9. **Project# 1005033**  
11DRB-70048 EXT OF SIA FOR TEMP  
DEFR SDWK CONST

Project # 1008261

Project Name: Skyline Heights

**Application Number:** 11DRB-70049, Minor - Preliminary/ Final Plat Approval

PLAT OF
LOTS 1-A-1-A AND 1-A-2-A, BLOCK 41
SKYLINE HEIGHTS

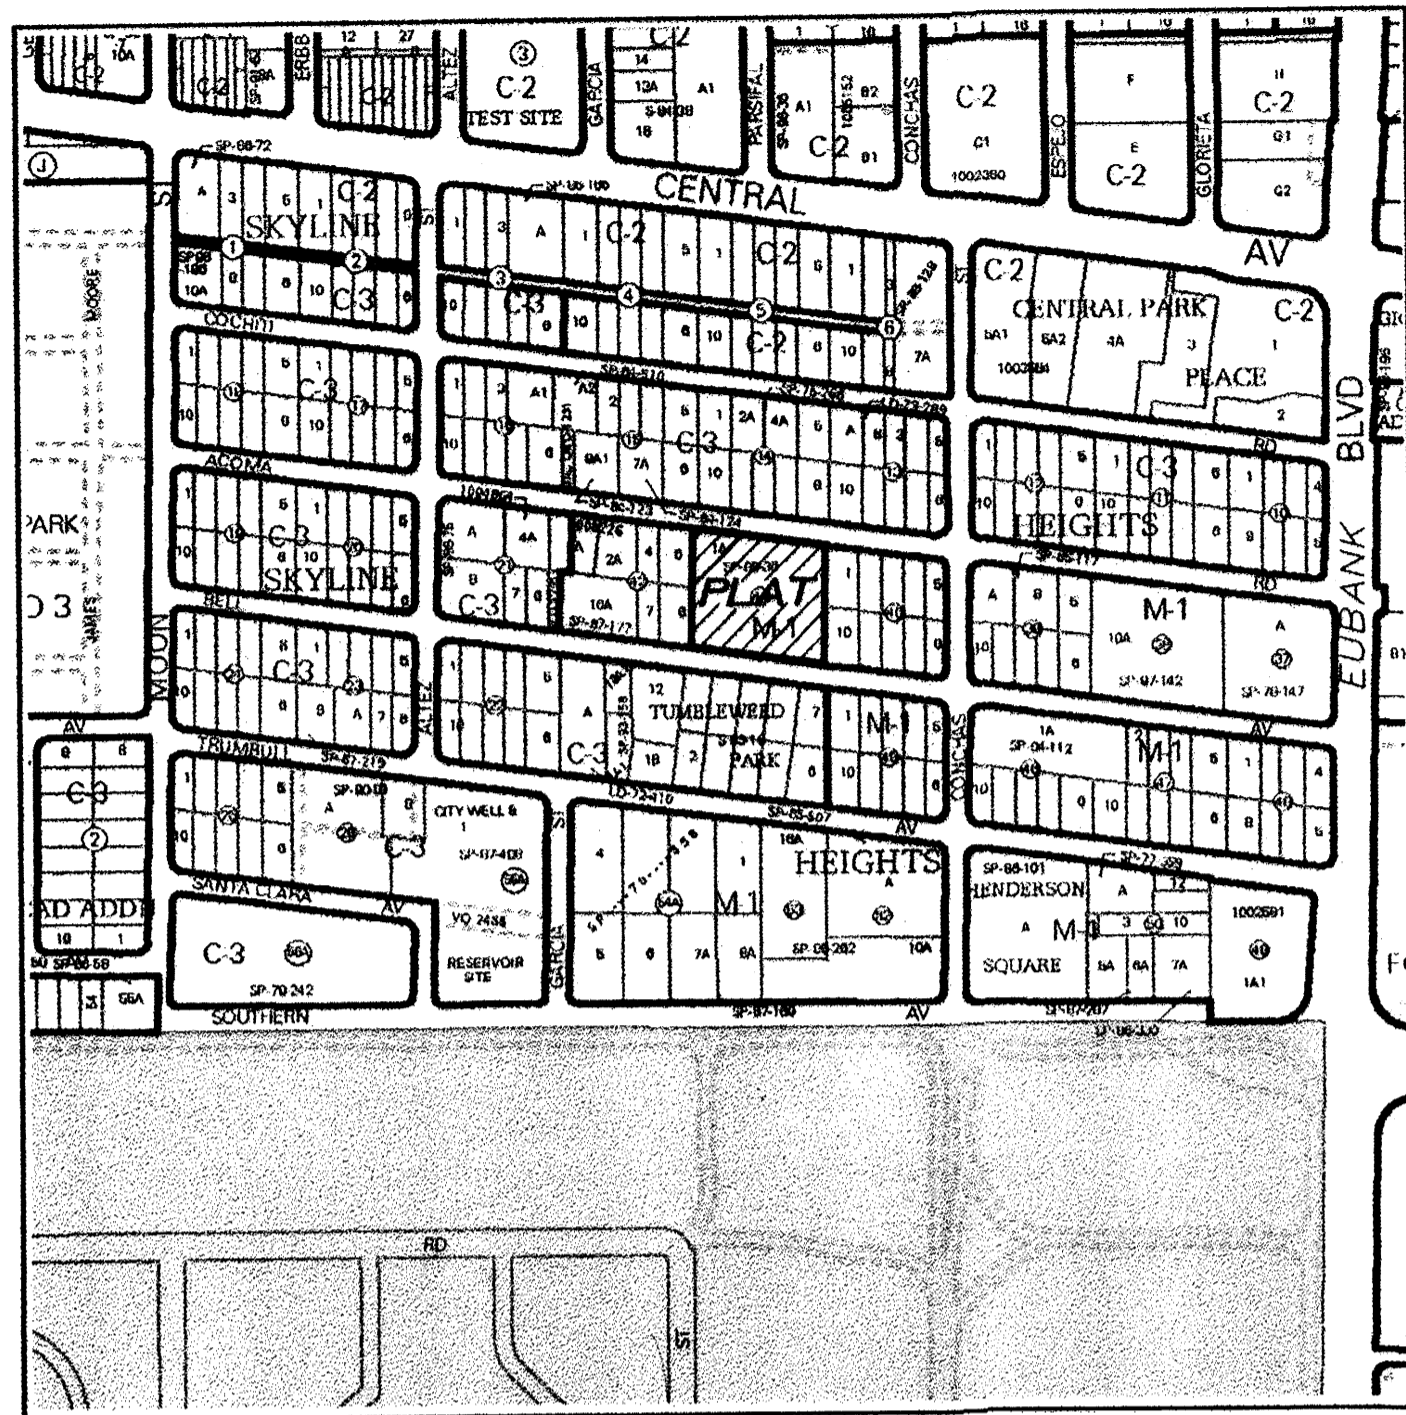
**TRANSPORTATION:** verify adequate ROW

**PLANNING (Last to sign):** verify adequate parking, dxp

ENGINEER'S SEAL	LABORER'S UNION 10001 BELL AVE	DRAWN BY DY
	TRAFFIC CIRCULATION LAYOUT	DATE 3/03/10
RONALD R. BOHANNAN P.E. #7868	TIERRA WEST, LLC 5571 MIDWAY PARK PLACE NE ALBUQUERQUE, NM 87109 (505)858-3100 tierrawestllc.com	2954-TCL
		SHEET # 1
		JOB # 29054

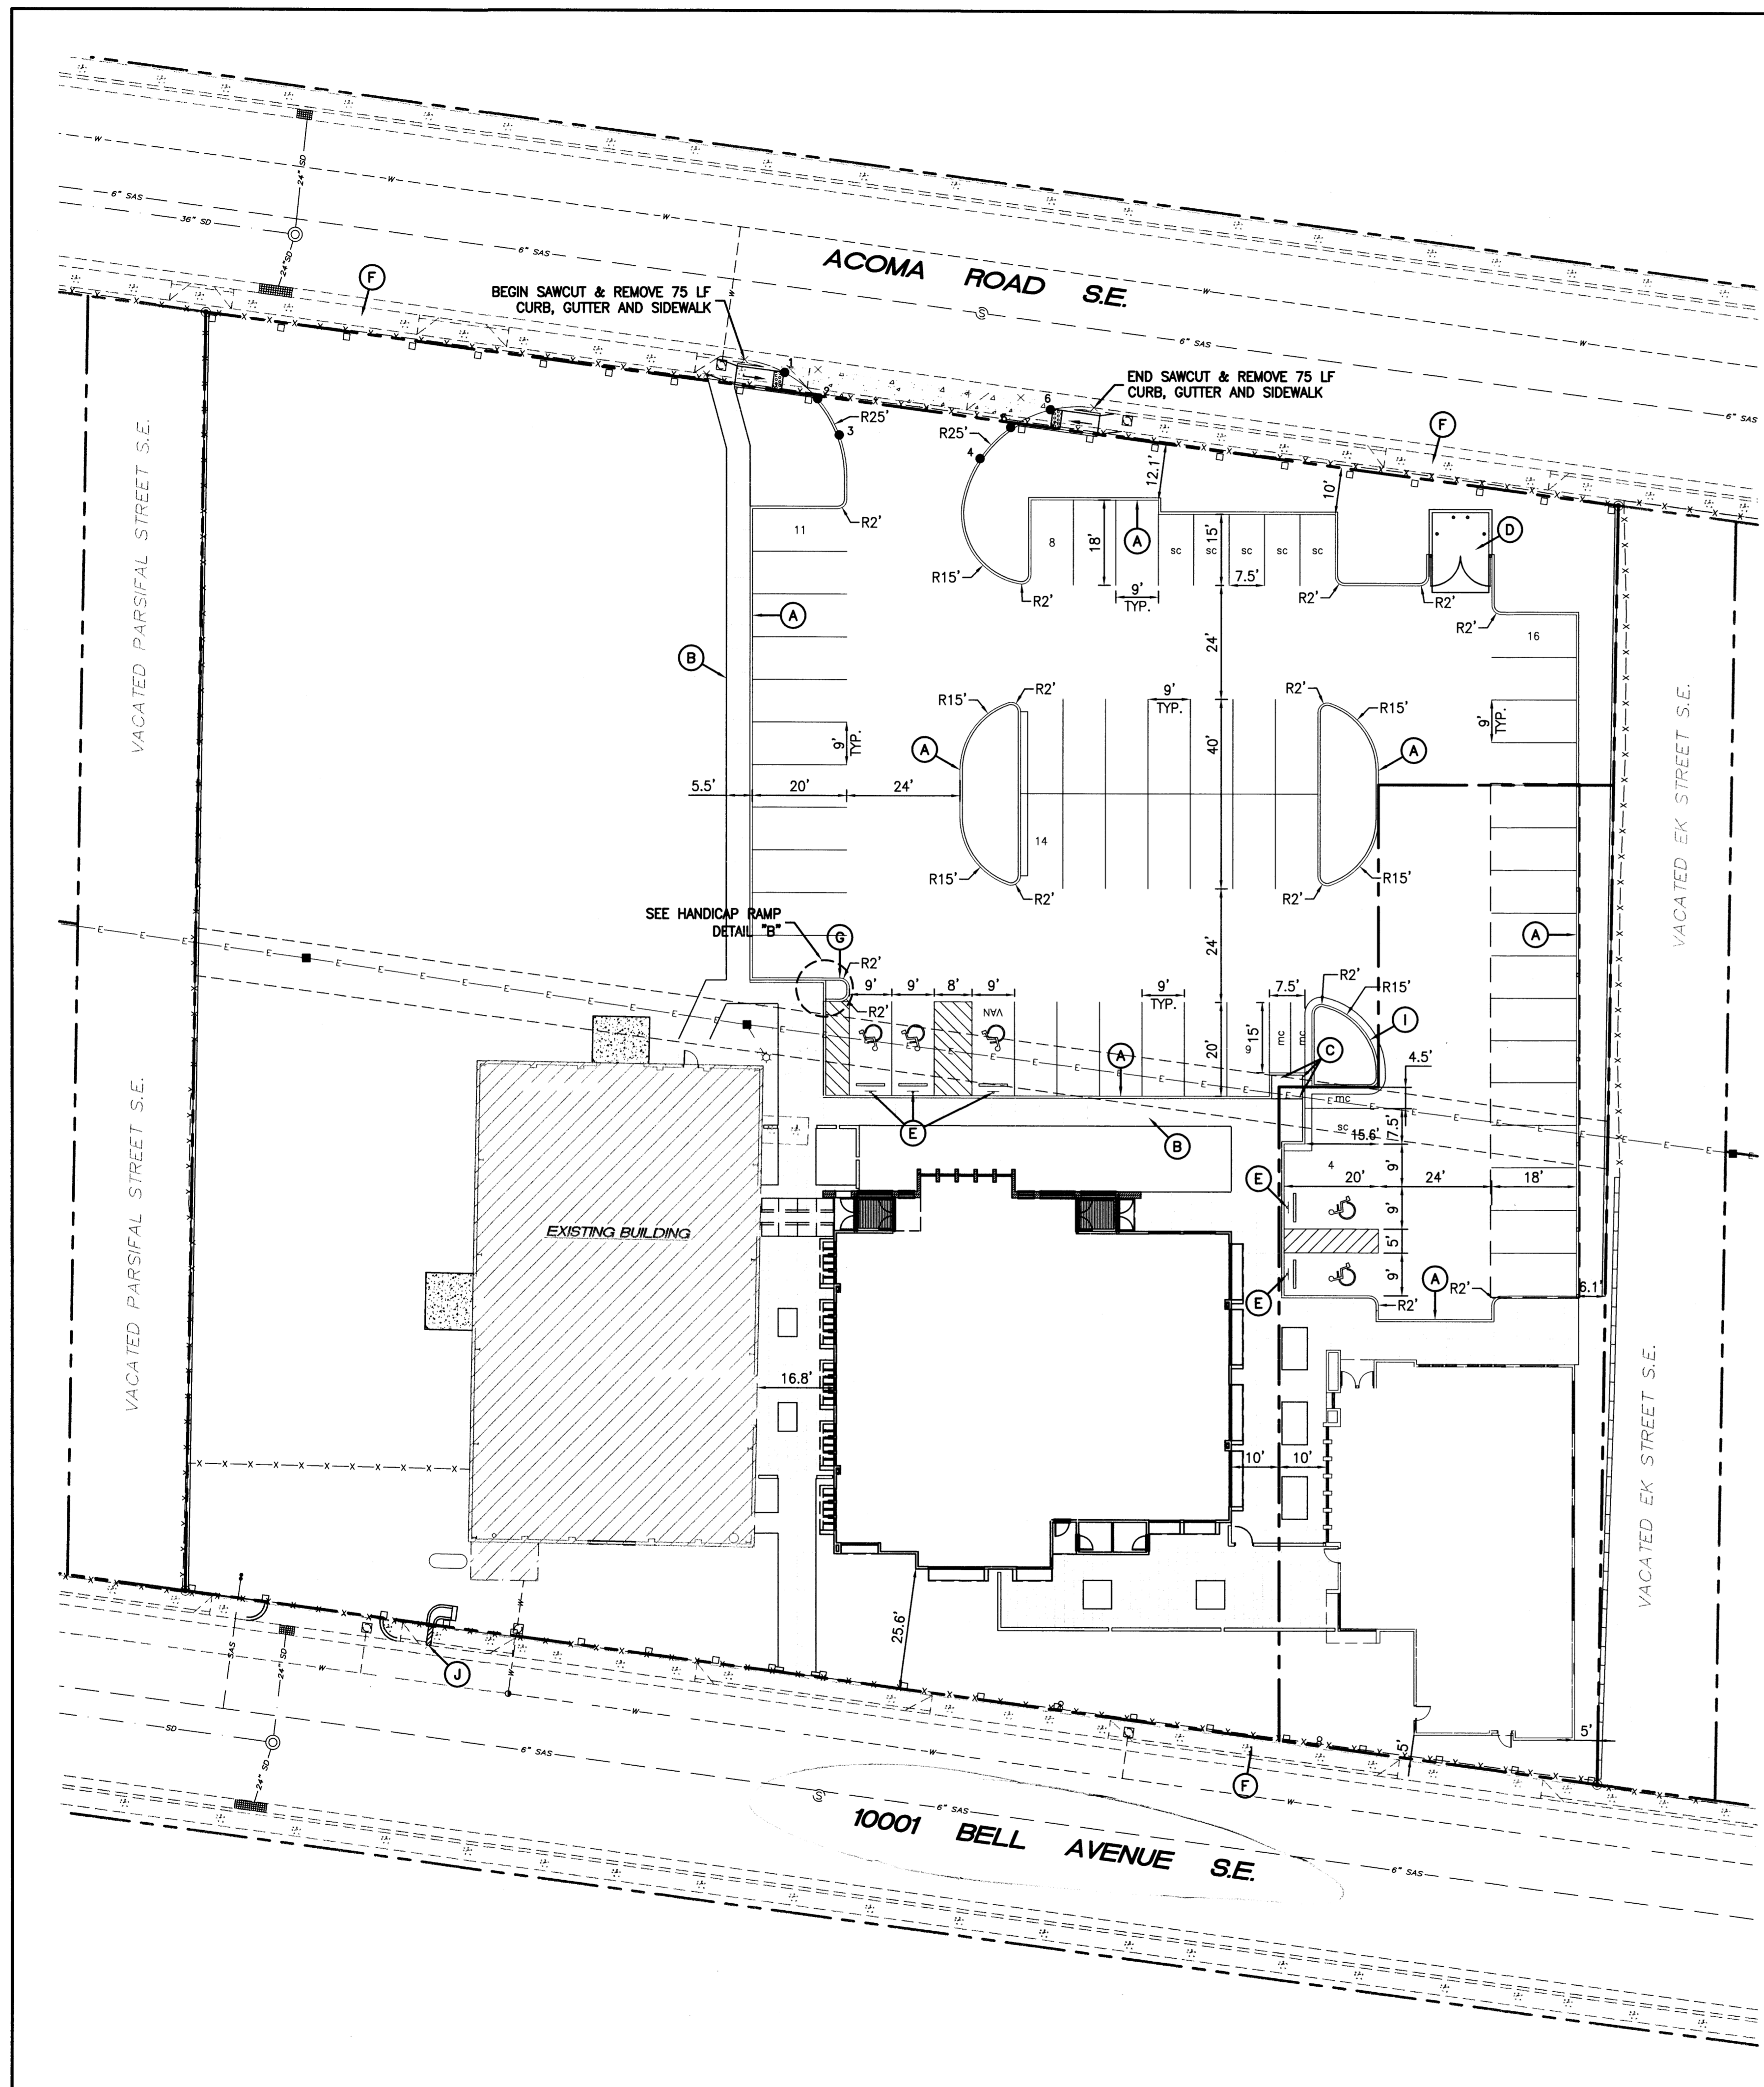
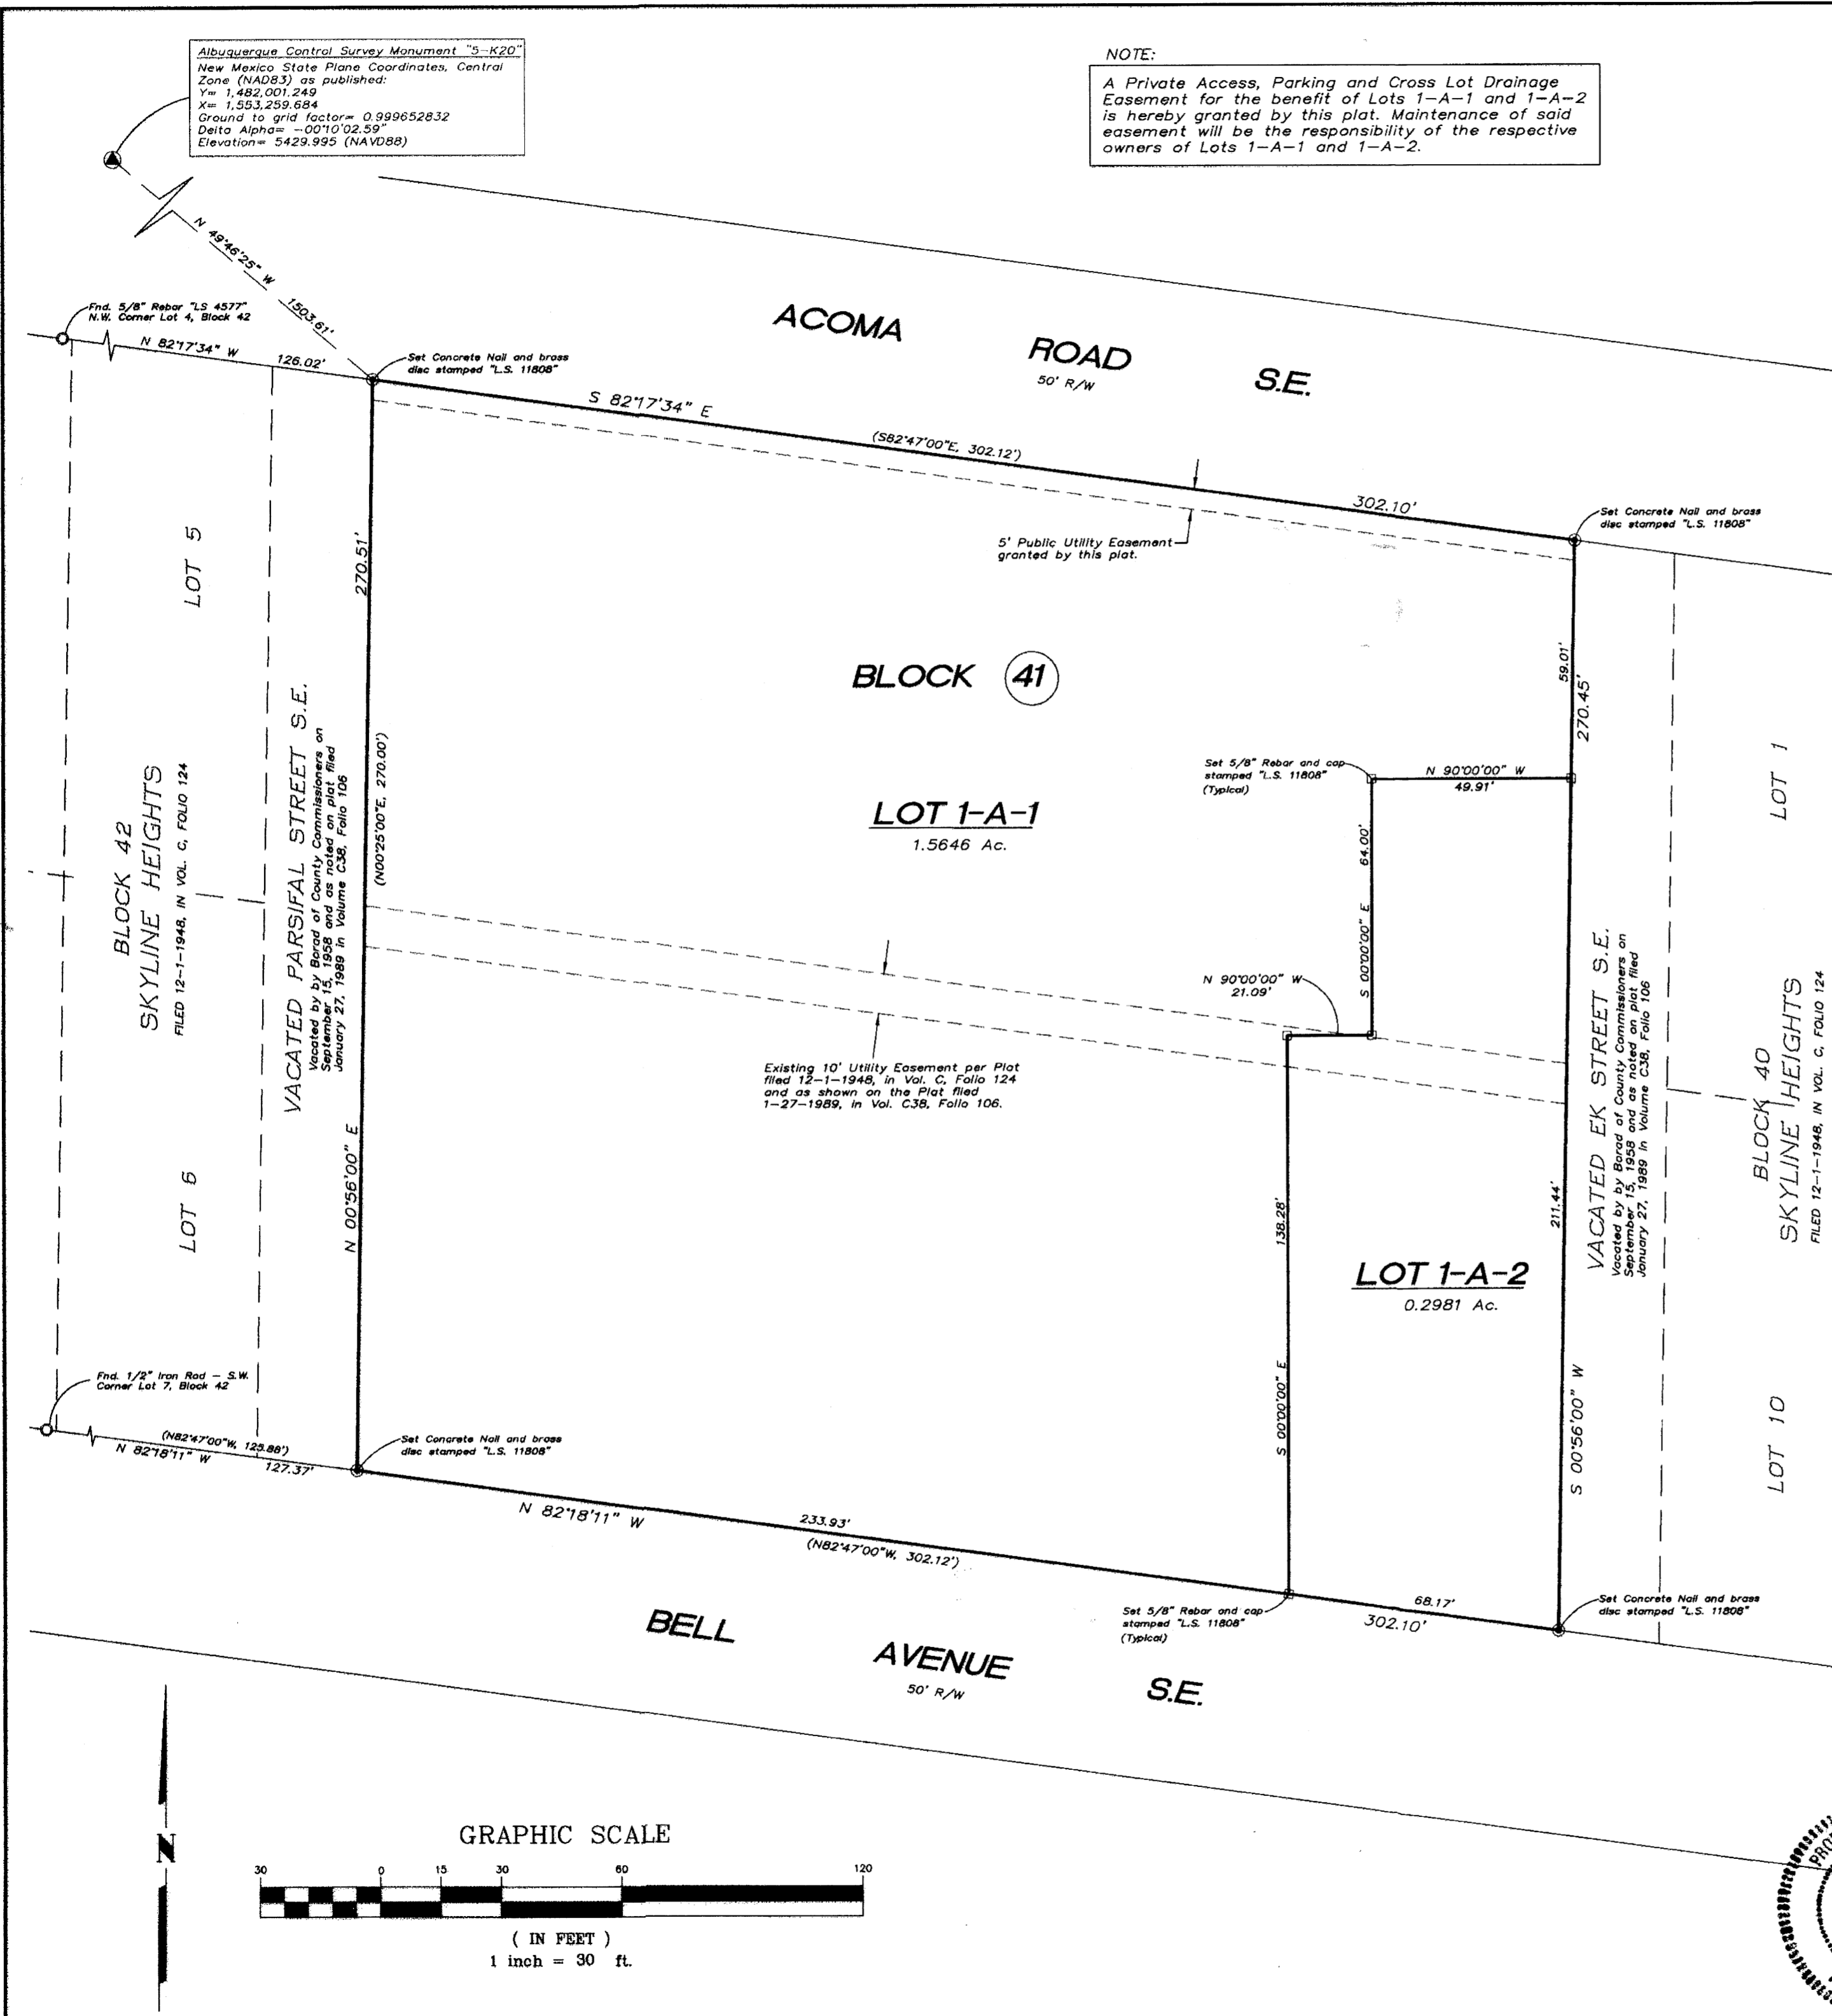
**TRANSPORTATION:** *- verify adequate ROW*

**PLANNING (Last to sign):** *verify adequate parking; .dxf*
